Transport
for NSW

**ENVIRONMENTAL ASSESSMENT FOR NORTH WEST PRECINCT REDEVELOPMENT
ROYAL PRINCE ALFRED HOSPITAL**

Thankyou for your letter dated 16 August 2012 regarding the request for Environmental Assessment Requirements for North West Precinct Redevelopment – Royal Prince Alfred Hospital (MP10_0166) under Section 75H of the *Environmental Planning and Assessment Act, 1979* for the above proposal.

DEPARTMENT OF PLANNING SUBMISSION
LOWER GROUND LEVEL PLAN

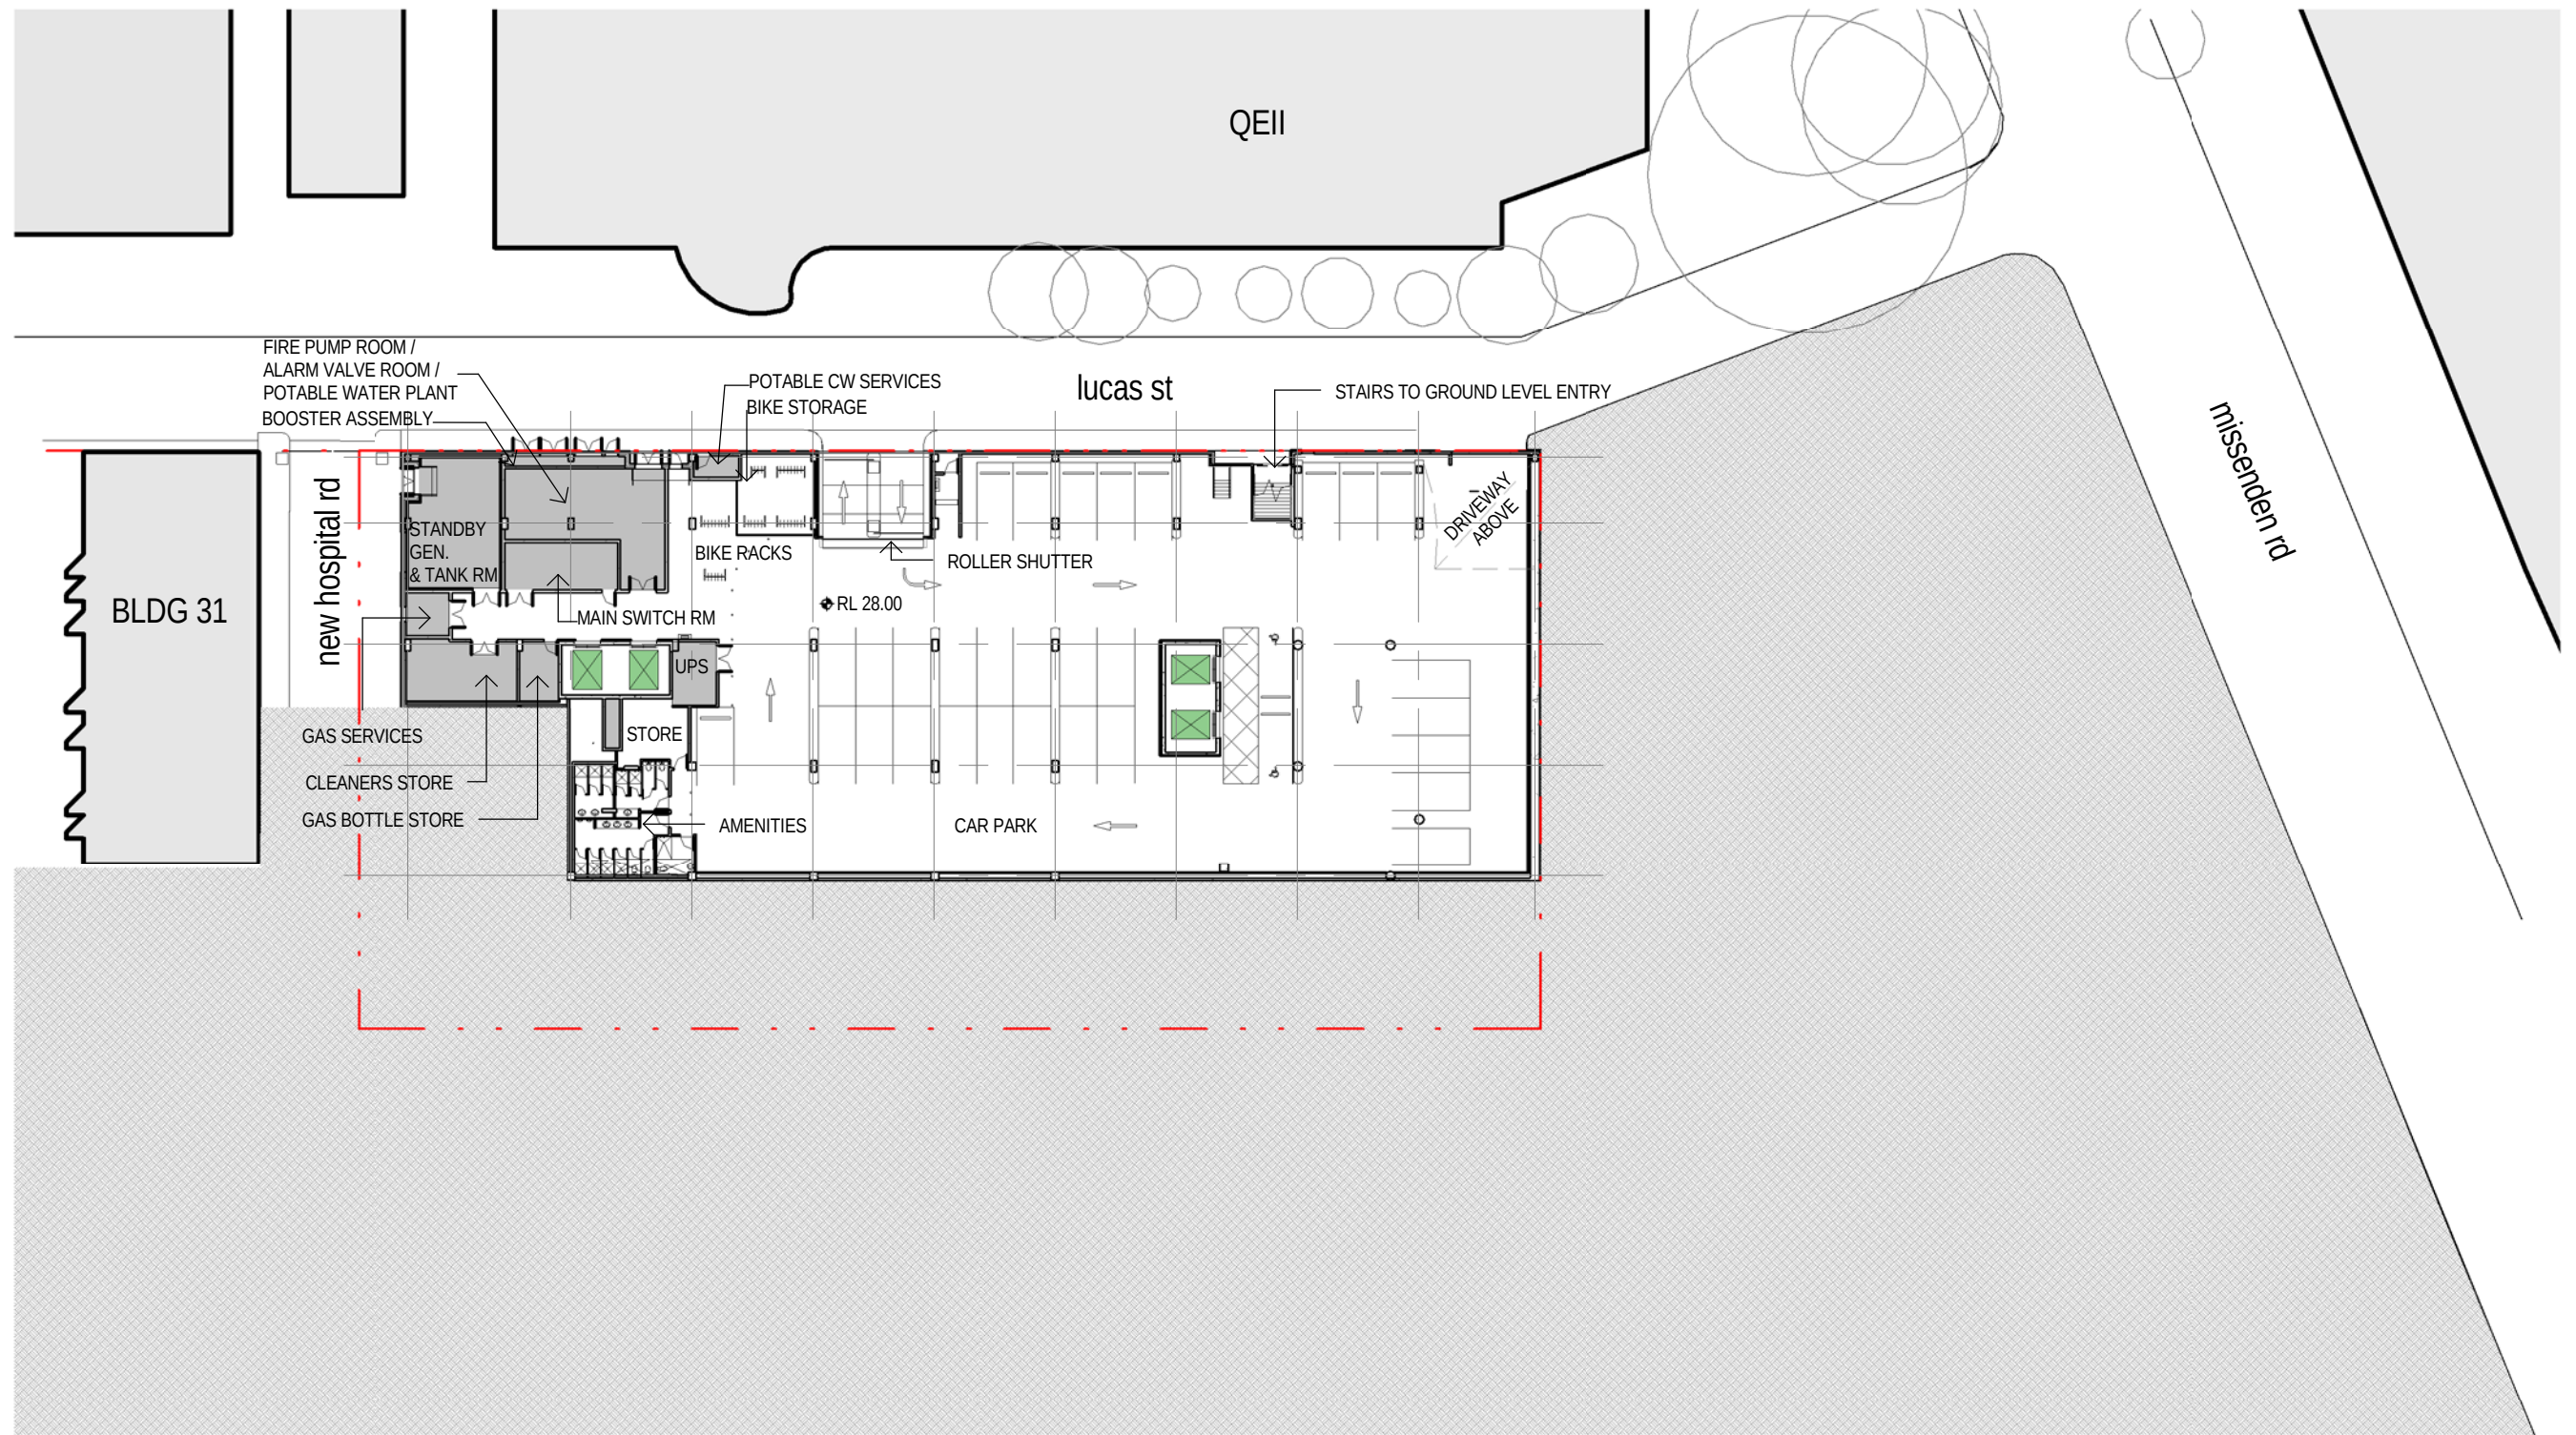
In addition, the proposed vehicle ramp driveway on Lucas Street and driveways on Brodie Street shall be designed to adopt pedestrian and cyclist safety measures in accordance with Council requirements and Australian Standards.

GROUND LEVEL PLAN

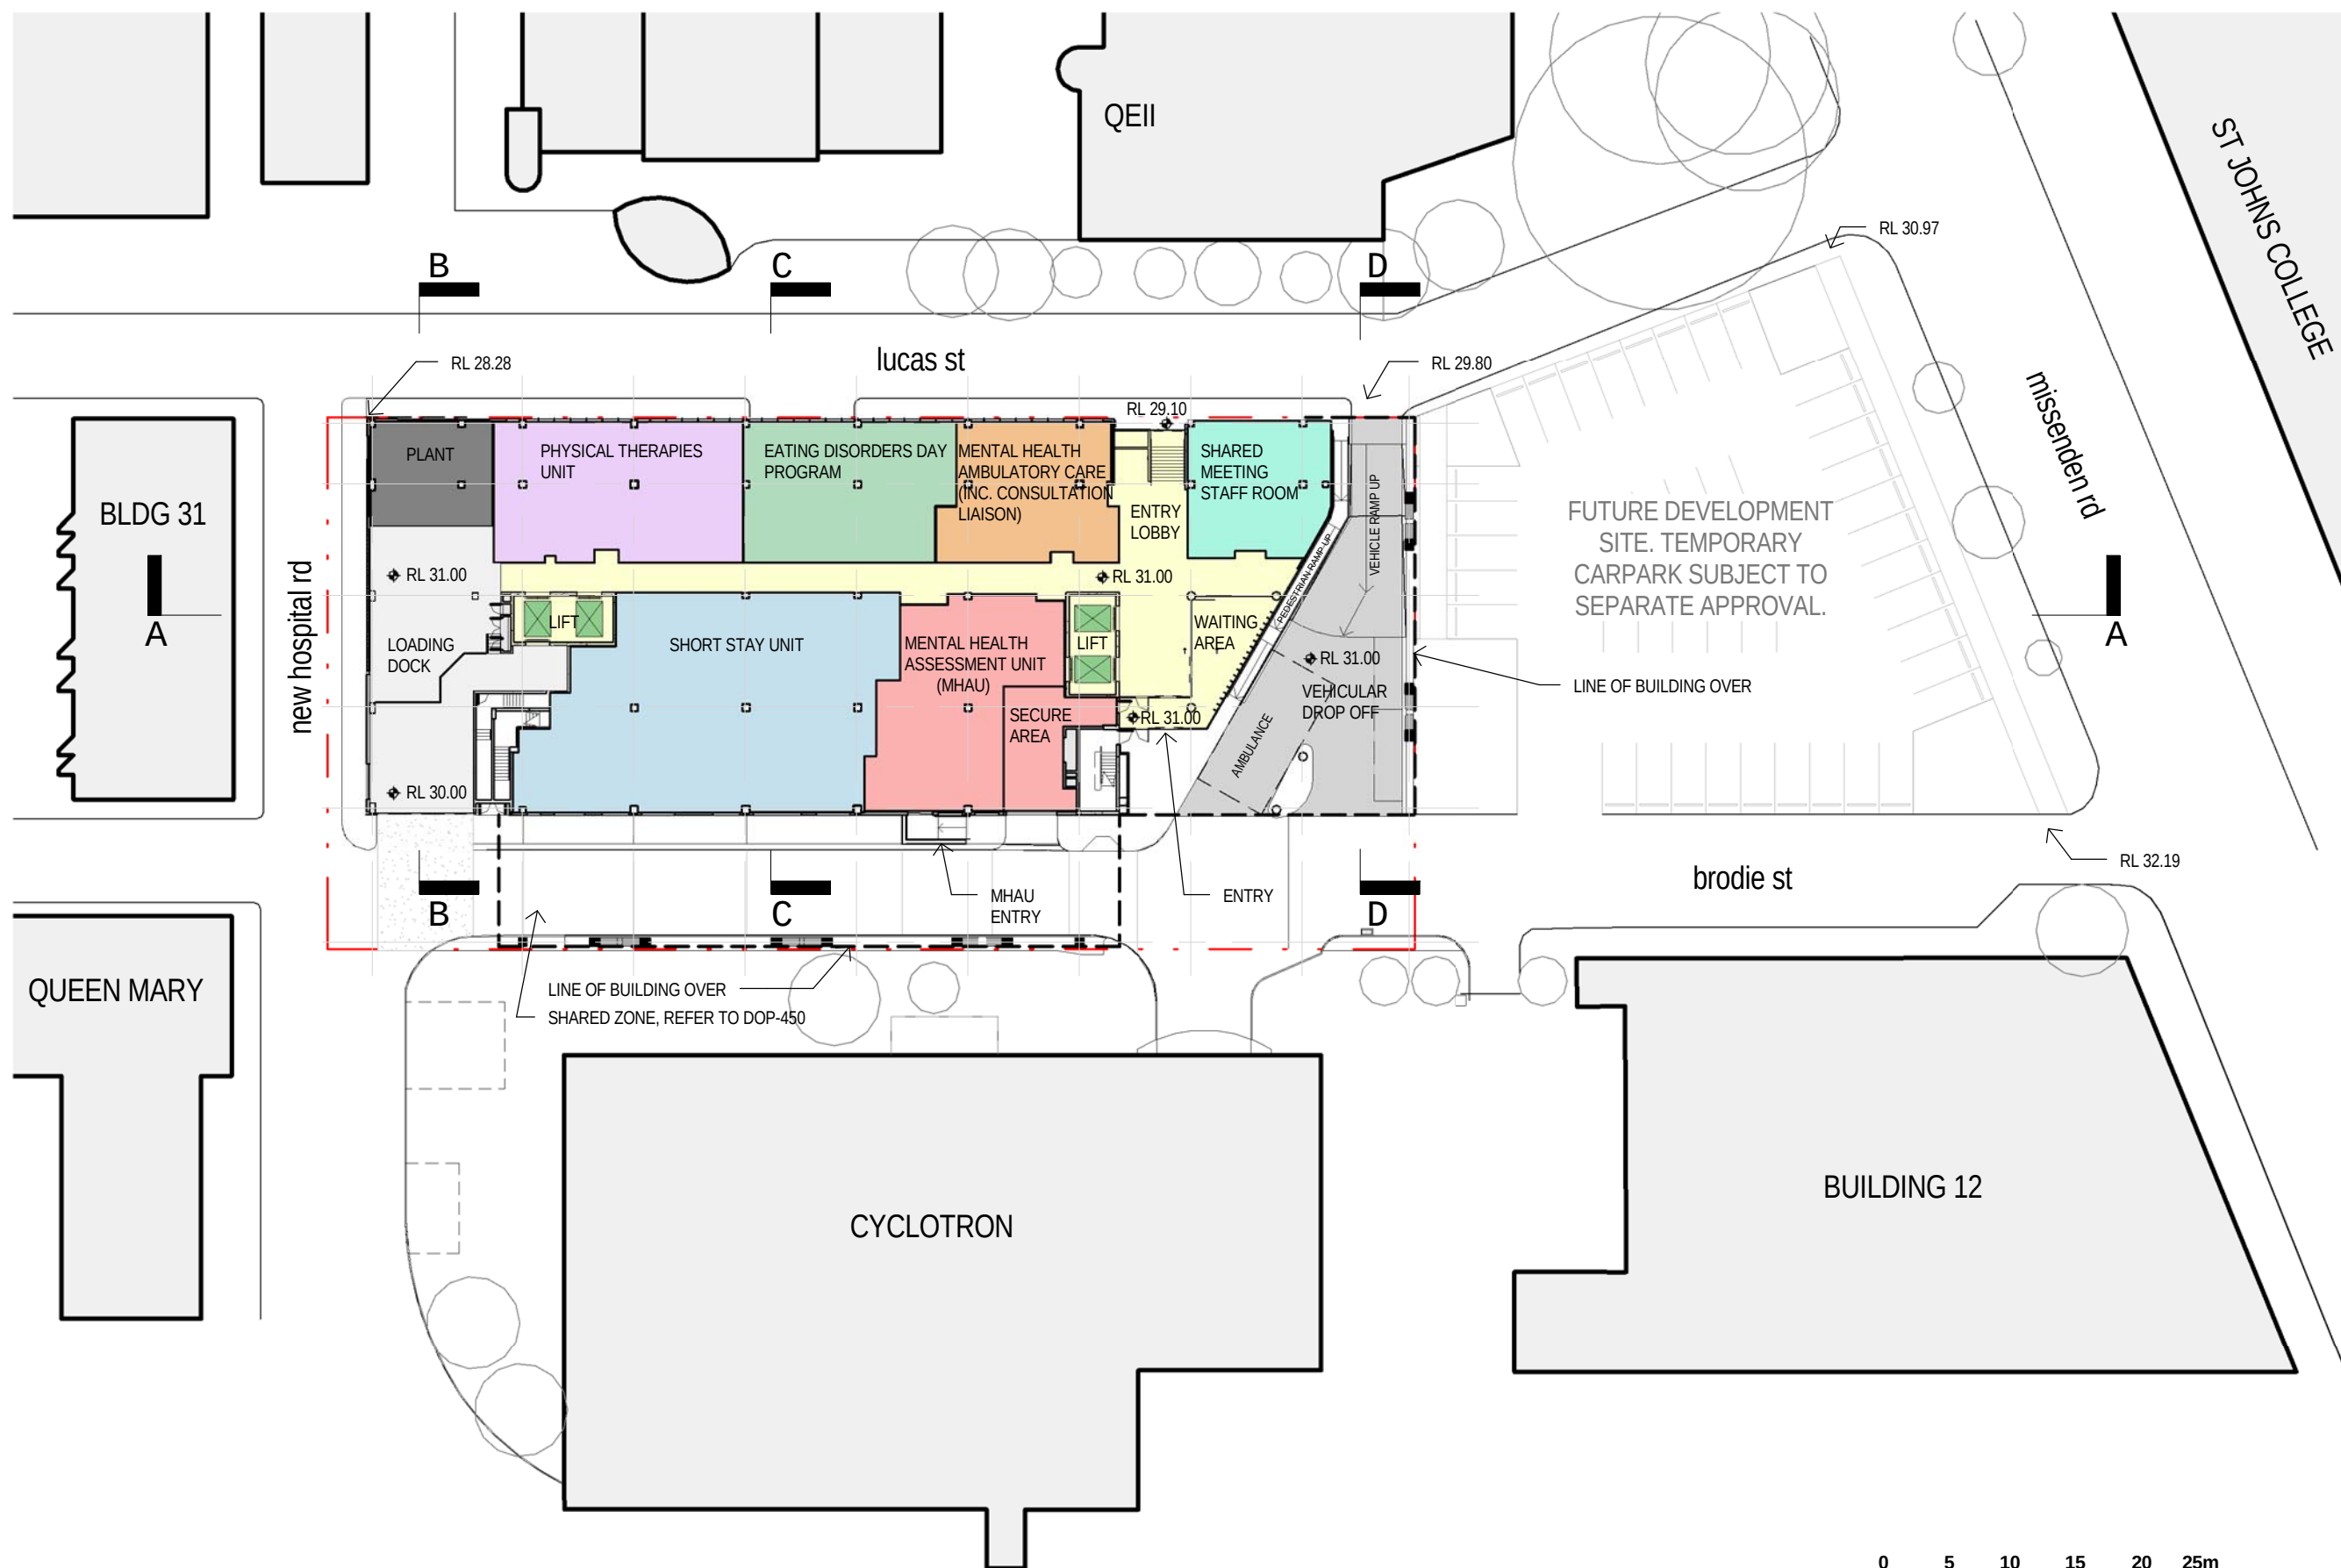
- The proposed Shared zone and associated speed limits on Brodie Street need to be approved by the Roads and Maritime Services, prior to determination by DP&I.
- The proposed landscape at the entry forecourt of the site fronting Brodie Street shall be designed to not obstruct the view of pedestrians and cyclists.
